Subject: 32 Lambert Lane
Fuquay Varina, NC 27526
Framing Inspection Letter
Harnett County Permit #: SFD2208-0054

Based on the request of the Contractor, I looked at 1 item from the framing inspection notice for code compliance. My assessment and recommendations are as follows:

**1ST FLOOR HEADER
 2ND FLOOR FRAMING**

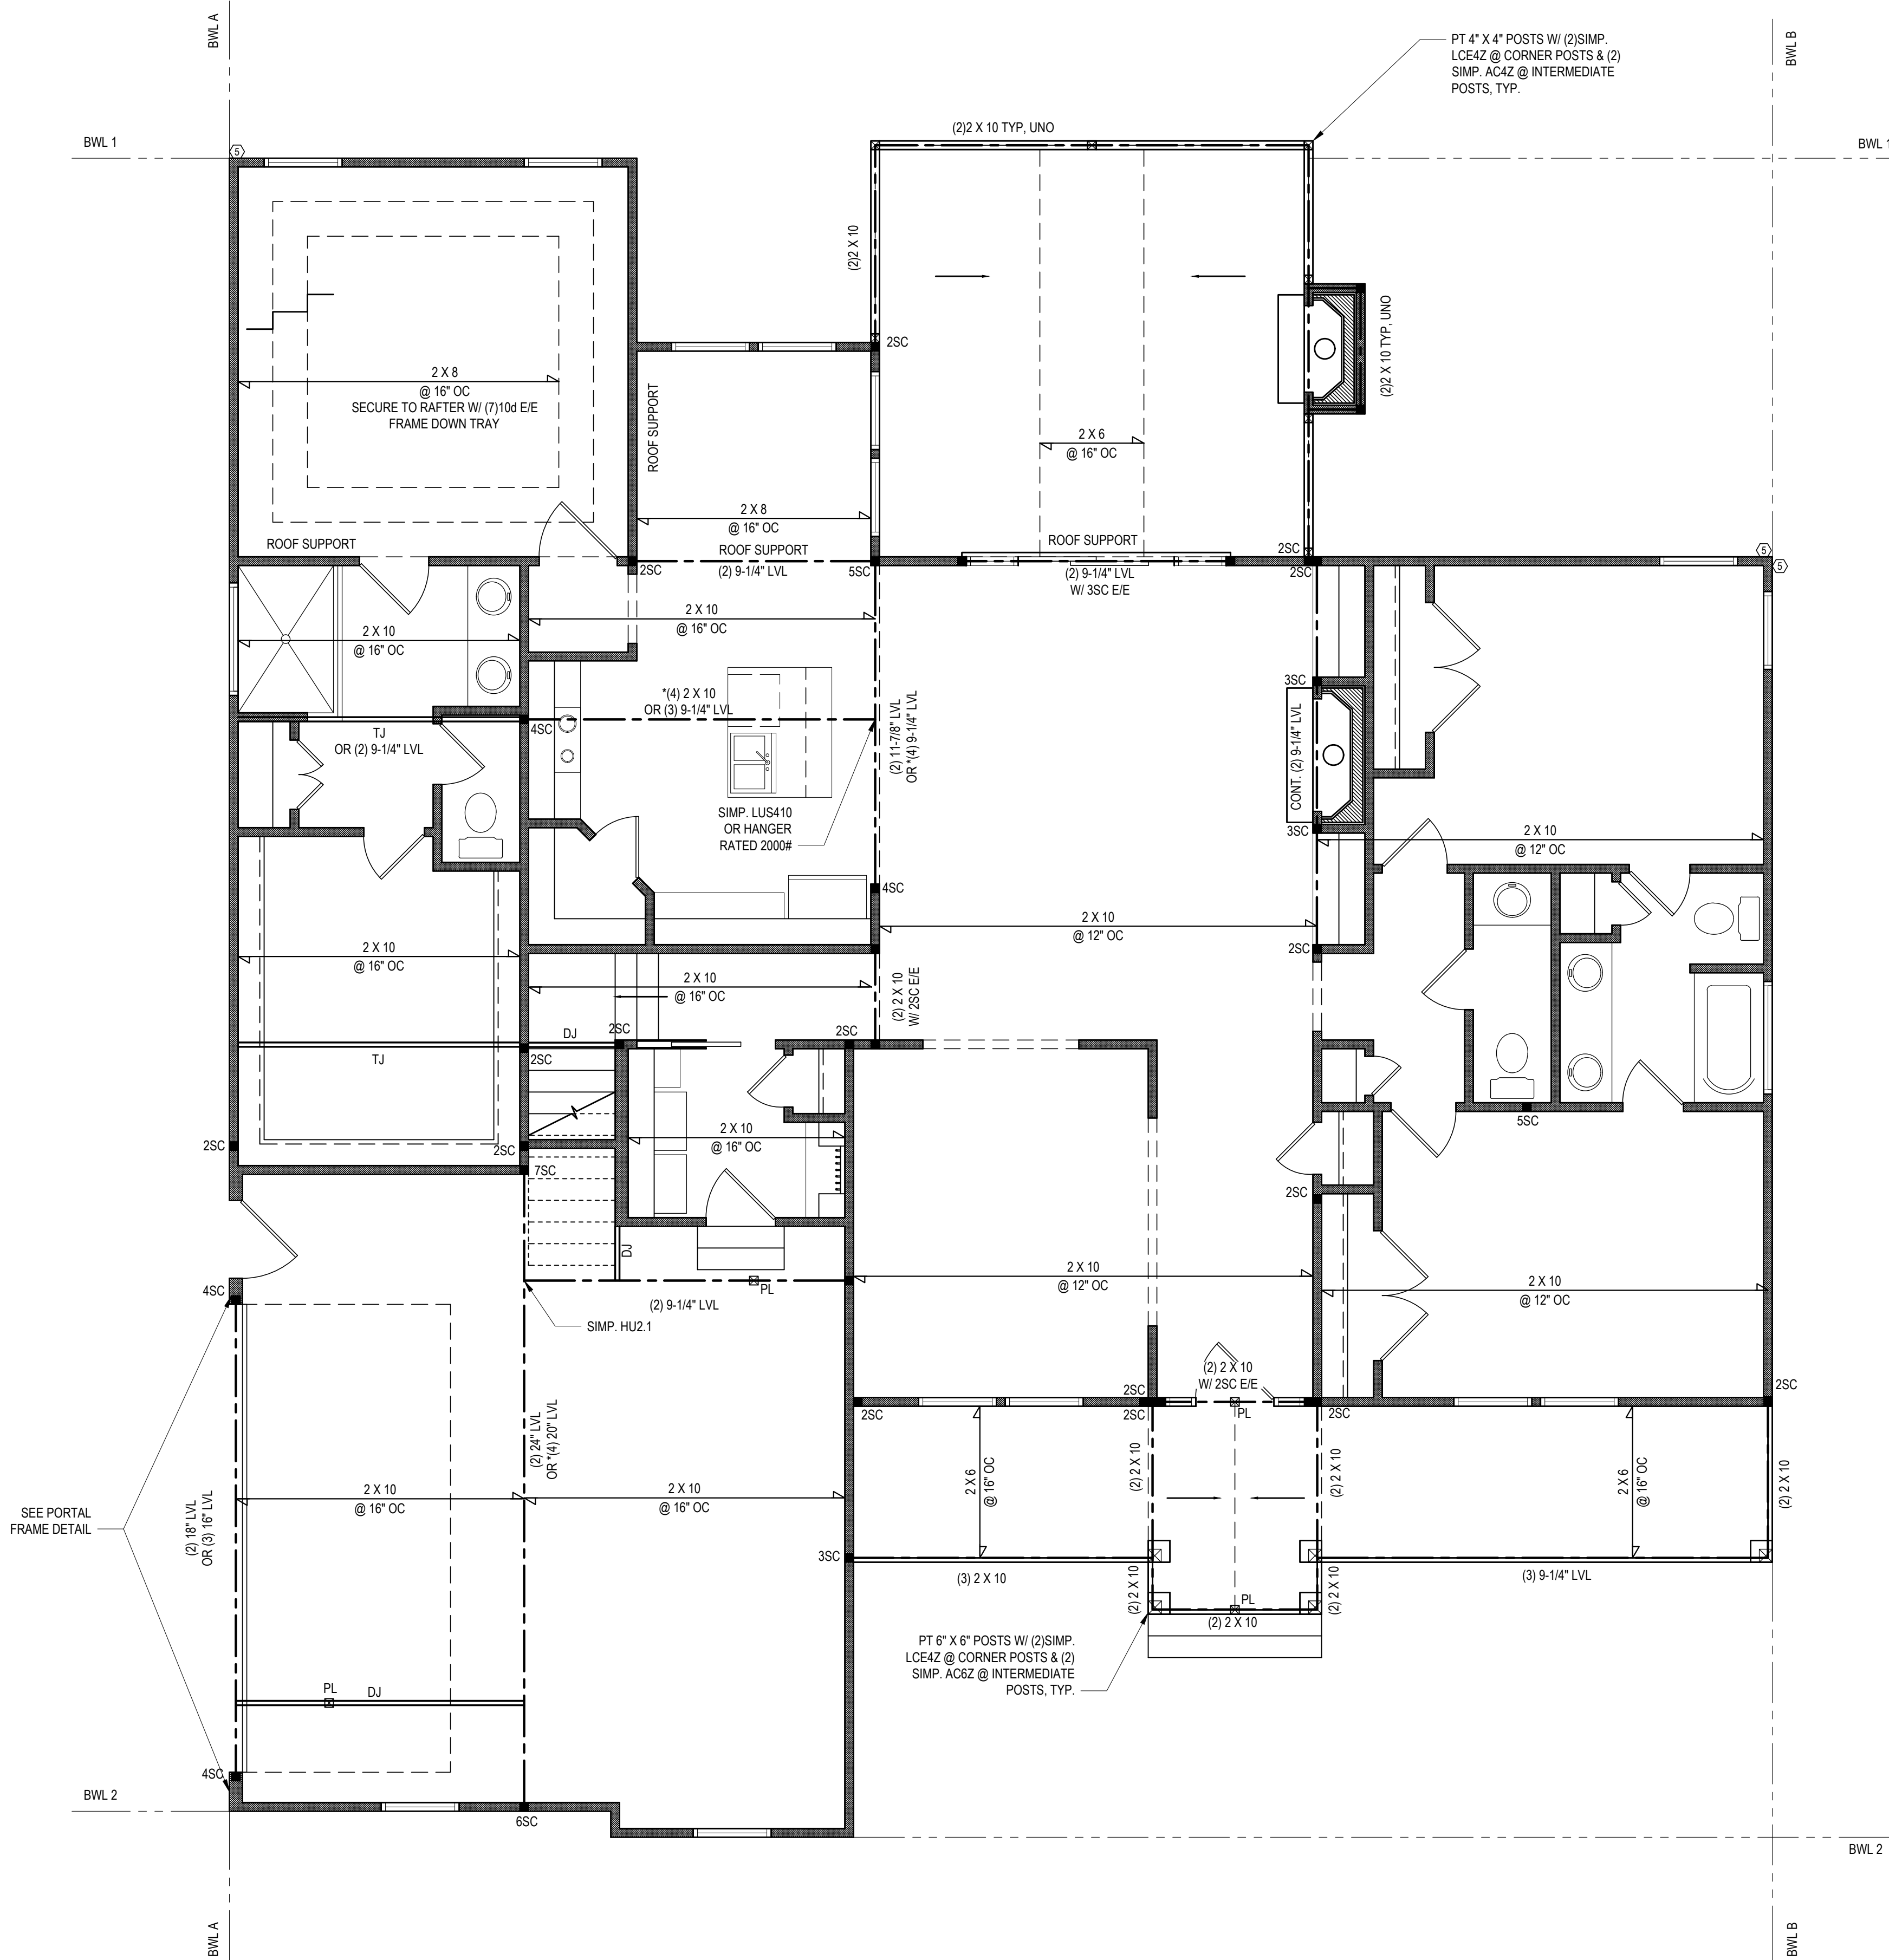
- The double 2x10 beam above the stairs to the 2nd floor was reduced to a double 2x6 beam. The double 2x6 beam is sufficient to carry the load from above.

The double 2x6 beam as installed meets all the requirements of the 2018 North Carolina Building Code for Residences.
